## SPR EA1N & EA2 PROJECTS

### DEADLINE 8 - POST HEARING SUBMISSION (CAH3)

Interested Party: SASES

Date: 25 March 2021

East Anglia ONE North and East Anglia TWO
Hundred River and Statutory Designated Sites Location

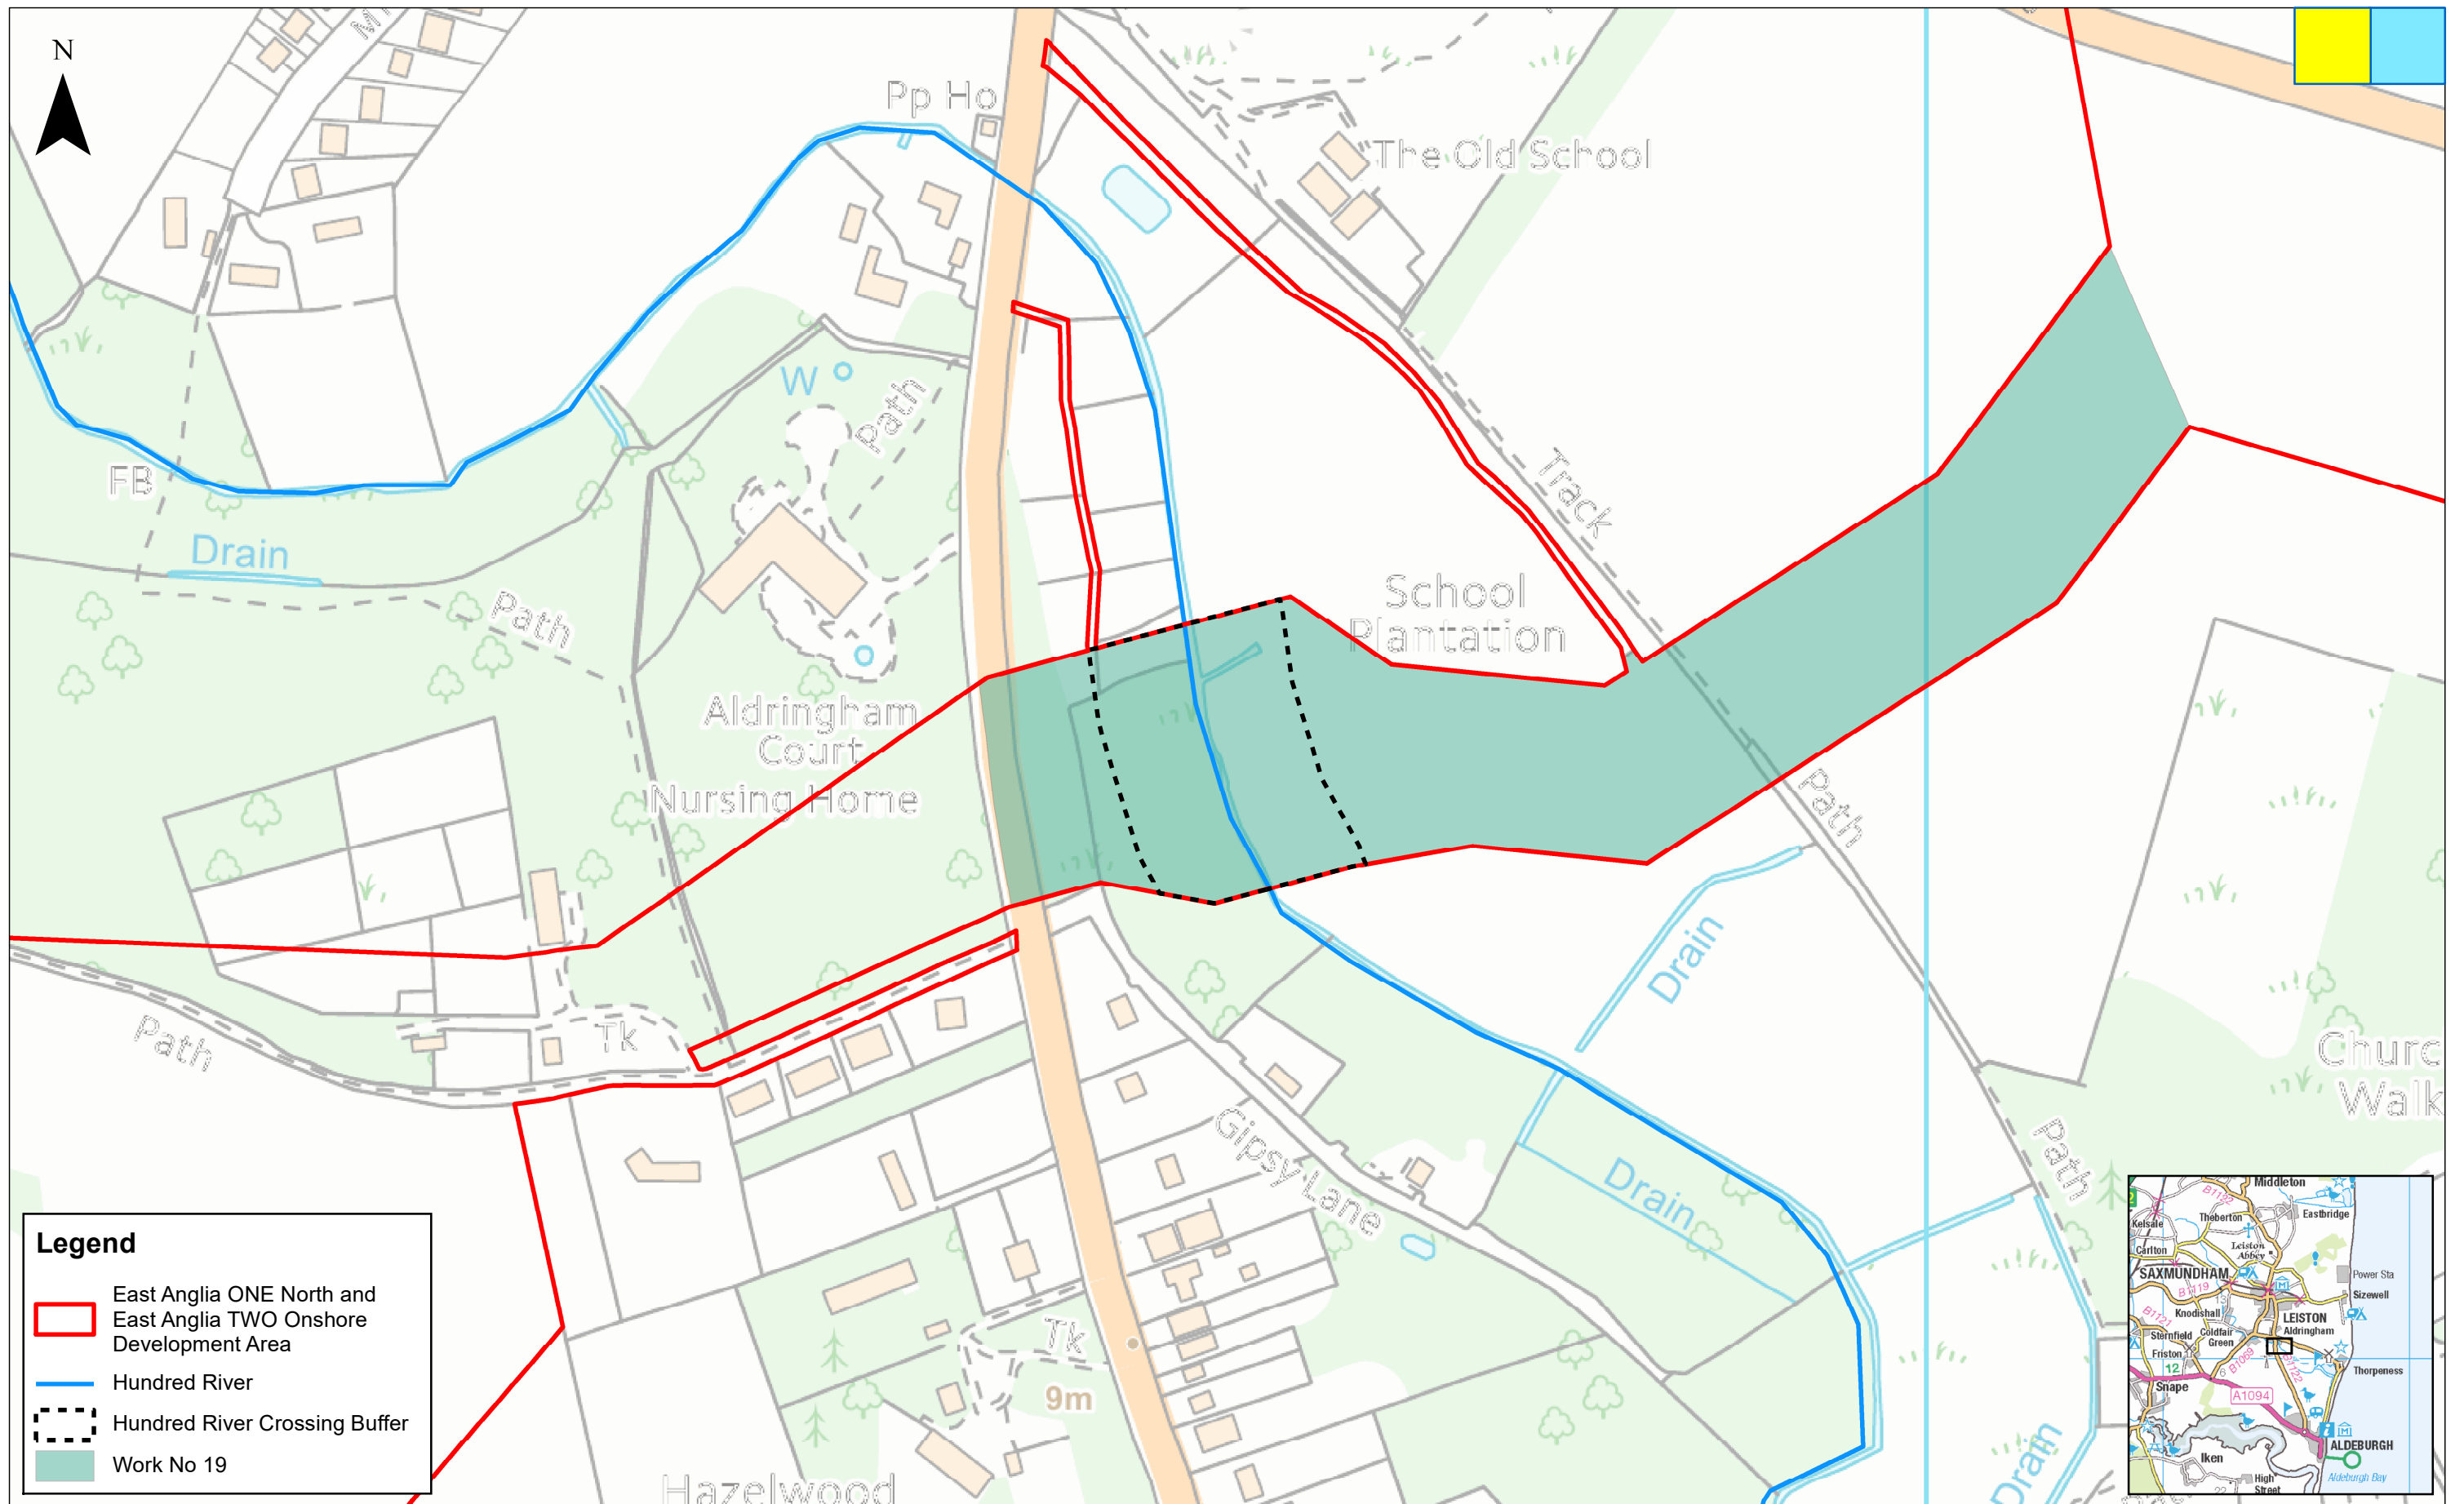
2. The Applicants referred at CAH3 and in Section 1.3 on page 1 of EA1N & EA2 Project Update Note' **[REP7-042]** to the maximum width of works at the River Hundred crossing having been reduced from 50m to 34m, but does not make clear that should both projects go ahead that would be  $2 \times 34 = 68\text{m}$ . The Project Update Note is confusing in this respect in that its title refers to both projects. The same comment applies to EA1N & EA2 Project Update Note **[REP3- 052]** 2.2 on page 6.
3. Evidence that the maximum width would be 68m may also be found in the Applicants' Outline Watercourse Crossing Method Statement **[REP6-041]**, Section 4.8 : Onshore Cable Route Width which is explicit at para 64:

4. The Applicants' documentation and their responses to questions posed by ExA's Mr Rigby at CAH3 Session 3 (at Video Recording time 33:13 to 47:34) were confusing as to whether the reduced width of 34 m refers to each project or both projects. Draft DCO Requirement 12 and paras 23 and 75 of Statement of Reasons **[REP7-013]** for **each** project both refer to a 34 metres width being required for that one project. The Applicant has variously mentioned the purpose for such wide separation as to make sufficient room for construction vehicle turning and to facilitate cooling of cables during the Operation phase. It is not clear why such a large spacing of the cable ducts is required only at the watercourse.

A width of 68m is 250% wider than the maximum width commitment of 27.1m for the cable route at the Aldeburgh Road pinch point, just a few metres away and would seem excessive for vehicle turning purpose.
